Overshadowing Statement

Berrite Limited, Iron Bridge Road South, West Drayton, UB7 8HY

June 2023

Existing - MARCH 20th 9.00 am

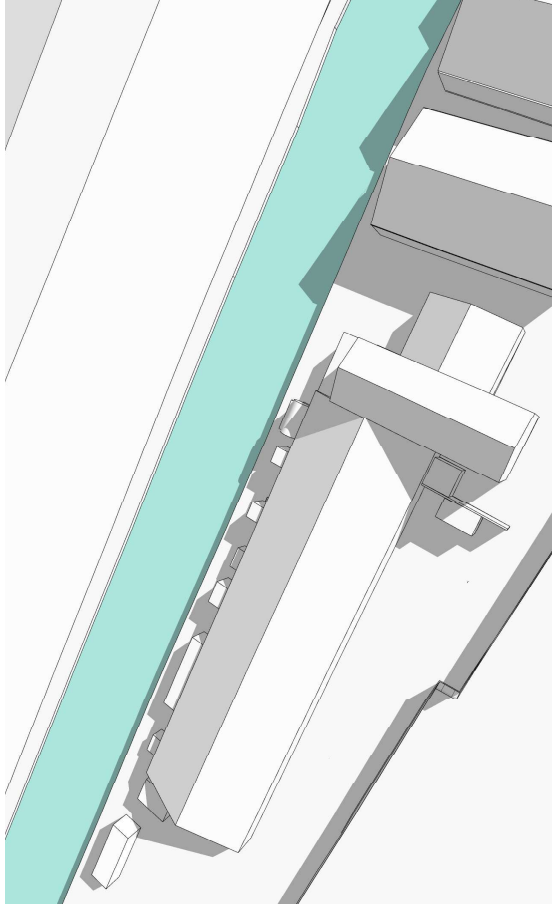
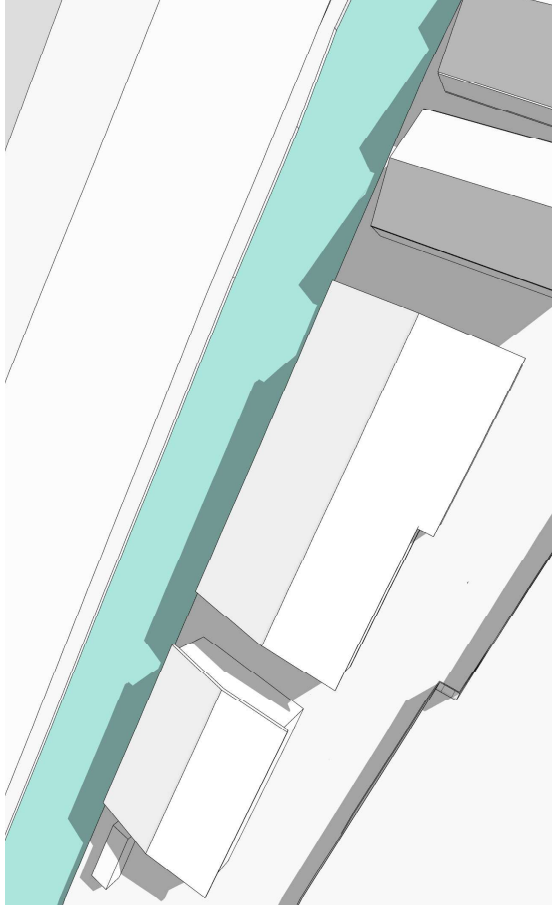
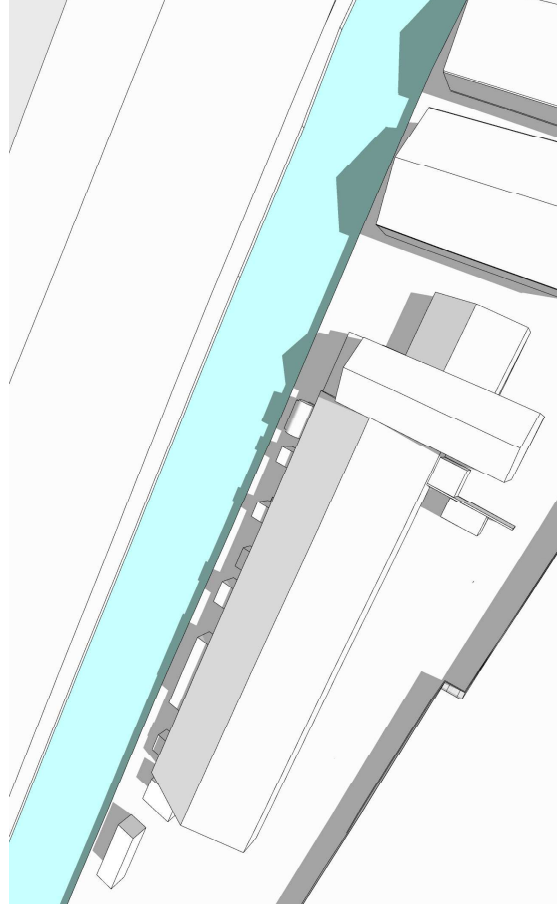
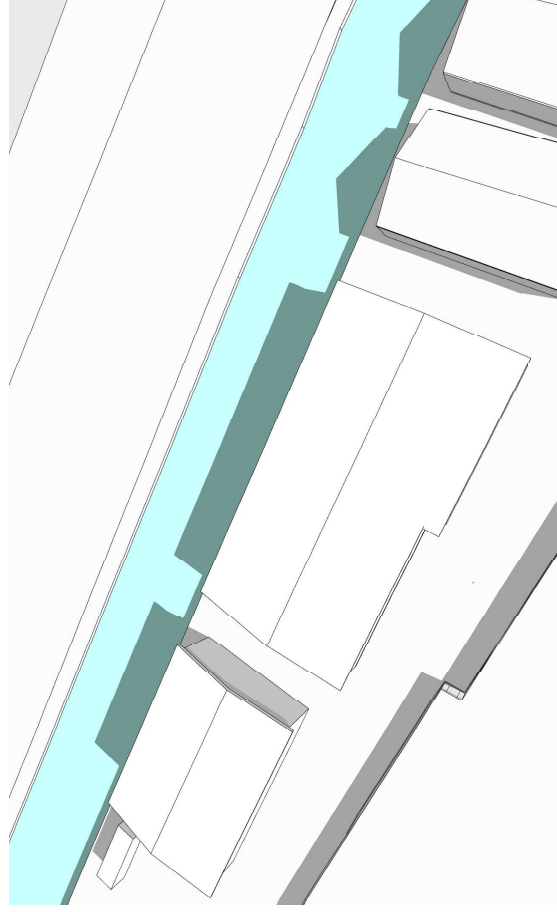
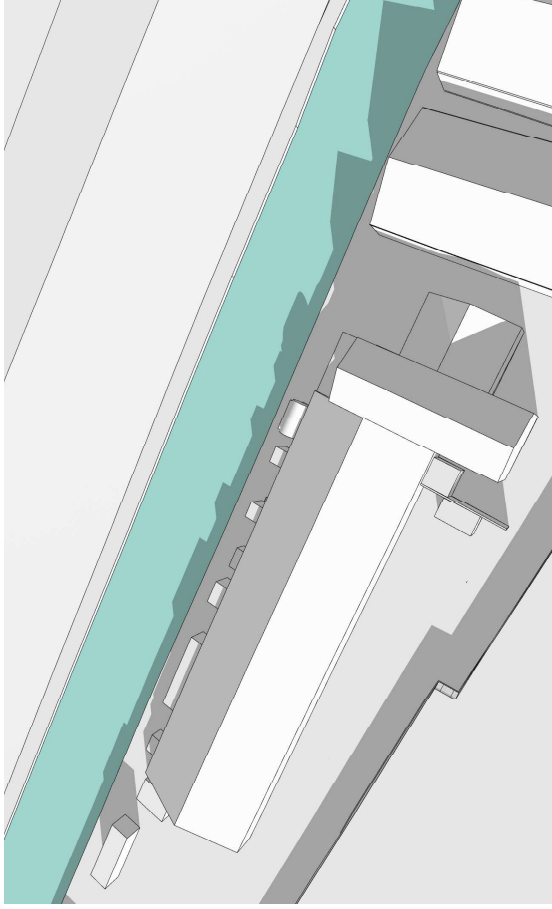
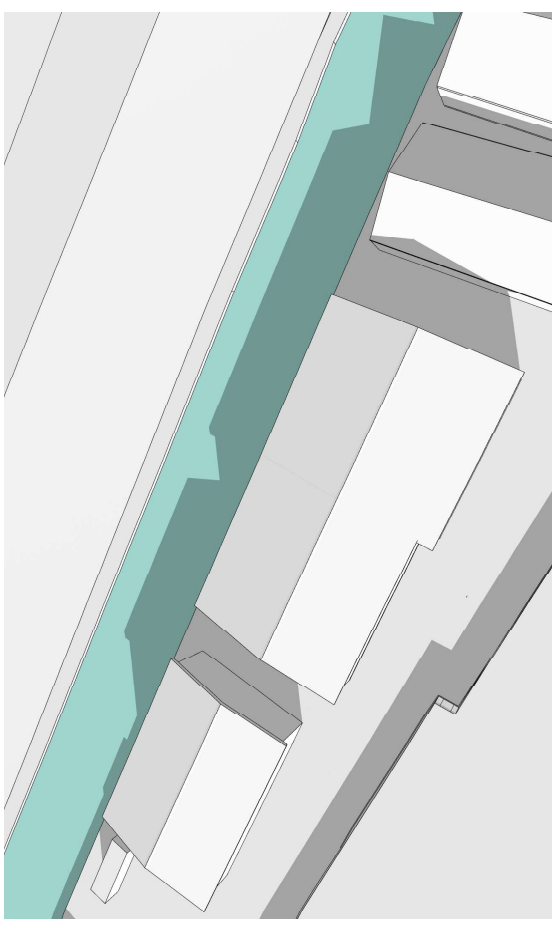
- The proposed development due to its overall size, height and proximity to the waterway would result in a level of overshadowing that would adversely impact on the ecological value of this section of the canal and no assessment of this or mitigation measures are proposed to address this. The proposals would therefore be contrary to Policy SI 17 of the London Plan, 2021, Policy EM7 of the Hillingdon Local Plan: Part 1 - Strategic Policies (2012) and Policies DMEI 8 & DMHB 11 of the London Borough of Hillingdon Local Plan Part 2: Development Management Policies (2020) and the advice and guidance contained within the NPPF.

- due to the height, massing, and proximity of the buildings to the canal there would be significant overshadowing of the waterspace as a result of the proposals. This level of shading would be detrimental to the biodiversity and aquatic ecosystems.
- without a shading study it is difficult to assess the impact of shading on the canal corridor, potential effects on biodiversity or how well the proposed planting would establish given the area would likely be shaded by the proposed buildings.
- No information has been provided to demonstrate that there would be no adverse shading to the canal and that an effective landscaping buffer could be created. This detail should be provided for consideration prior to determination.

- is a minor increased level of shading between the current and proposed building southern bank on the 20th March at 9am and 12.00pm and a significant increase in shading at 4pm;
- is minimal difference in shading between the current and proposed building on 21st June;
- is a minimal difference in shading at 9am, a slightly increased level of shading at 12pm and a significant level of shading at 4pm on September 23rd
- on 23rd December there is no significant difference in shading with the majority of the canal in complete shade throughout the day.
